Planning Officer: Amber Willard

Planning Application Ref: AW/297/19/HH

Location: Strawberry Cottage, Cypress Way, Aldwick, PO21 4DF

Description of works: Addition of a first floor and carport with 1st floor

Drawing:
Proposed car barn and storage

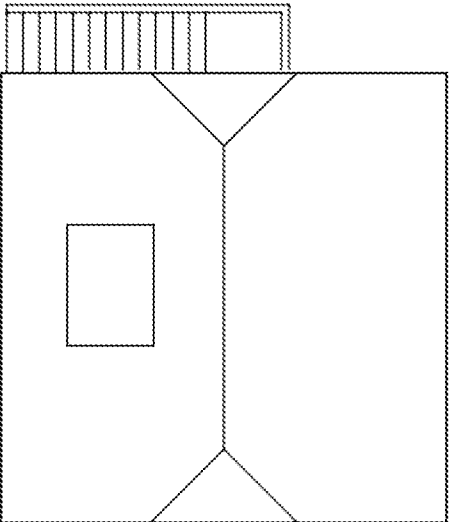
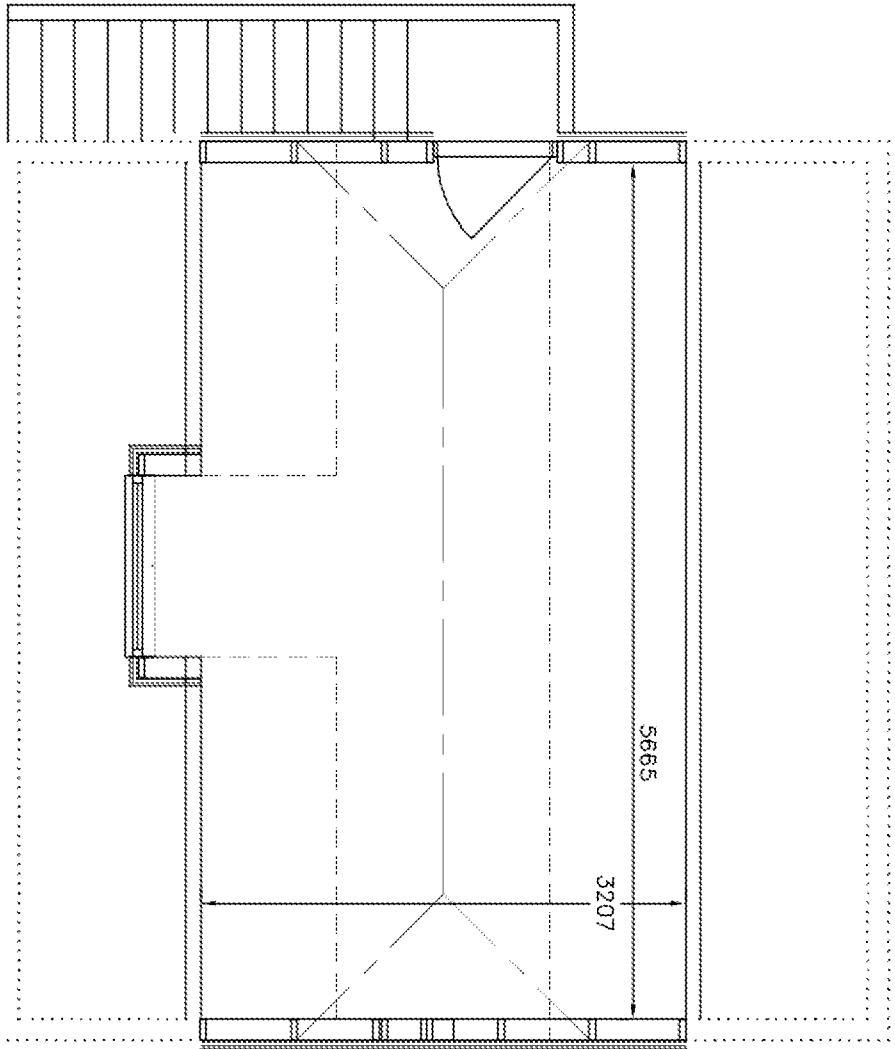
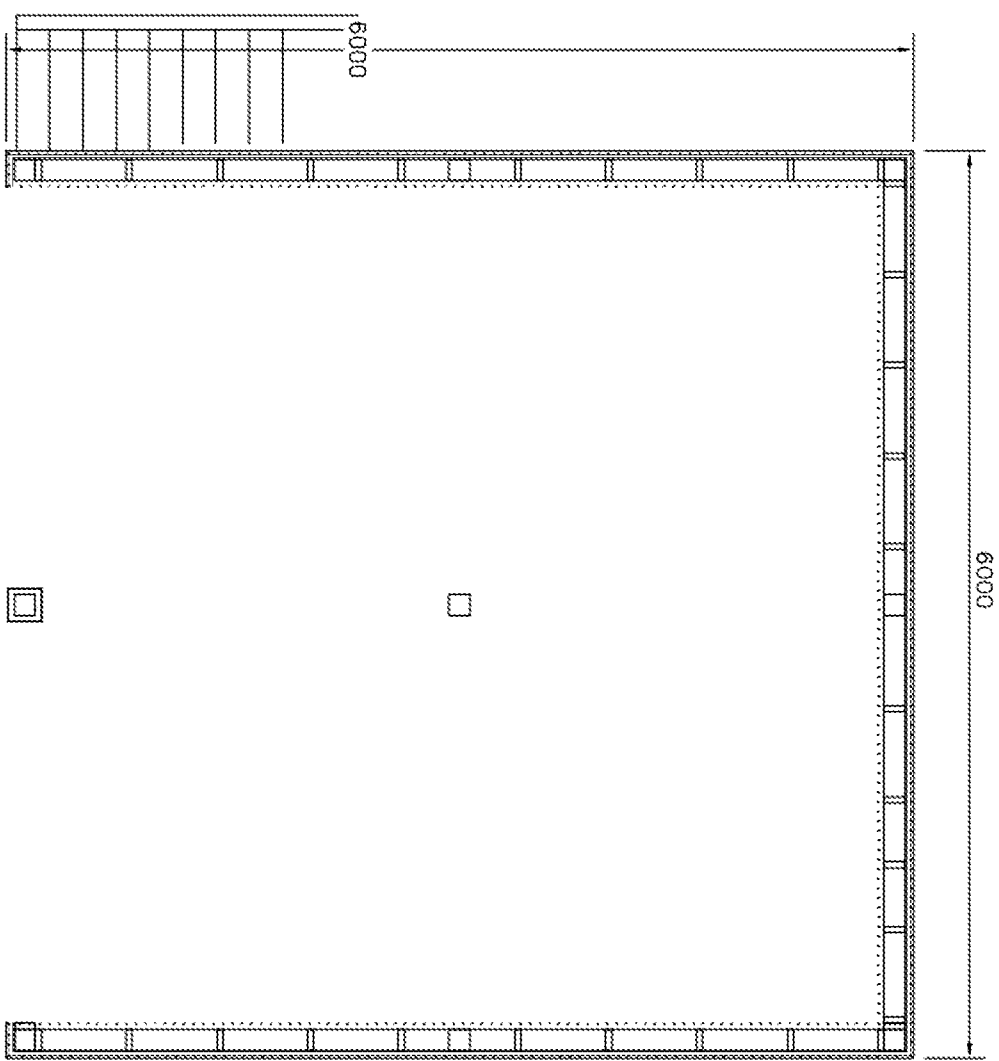
- The project architect has submitted a block plan, dwg. no. 2472/01/08 that shows the location of the car barn. Trees are shown for illustrative purposes only which is insufficient to be able to determine the full extent of the proposal's impact on trees, both above and below ground level. Any construction activity within this area will be taking place over the nominal root protection area (RPA) of mature trees (the subject of TPO) and will demand an ambitious engineering construction plan and suite of tree protection measures to mitigate risk of damage to the same. It may be more practical and desirable to eliminate that risk by choosing an alternative location that does not conflict with tree root growth.

- The principle of development to the main building as described is certainly achievable without undue detriment to retained trees, although we are yet to have sight of the necessary arboricultural report and plans to demonstrate this has been properly considered.
- The current proposed location of the car barn is going to impact on significant trees which are the subject of an Order (TPO) both above and below ground. Although it may be achievable in theory by adopting certain methods of working and tree protection measures; there is nonetheless a risk that attaches during such incursion of root protection areas. This is especially significant where the trees in question are of high amenity value.

- As it stands, I am unable to lend this scheme my support and so register an **OBJECTION**.
- The applicants will need to employ the services of an Arboricultural Consultant to carry out a tree survey exercise and then prepare an Arboricultural Impact Assessment (AIA) which must be inclusive of; a 'Tree Survey Schedule', a 'Root Protection Area (RPA) Schedule' and a 'Tree Constraints Plan' – with the trees accurately plotted on same.
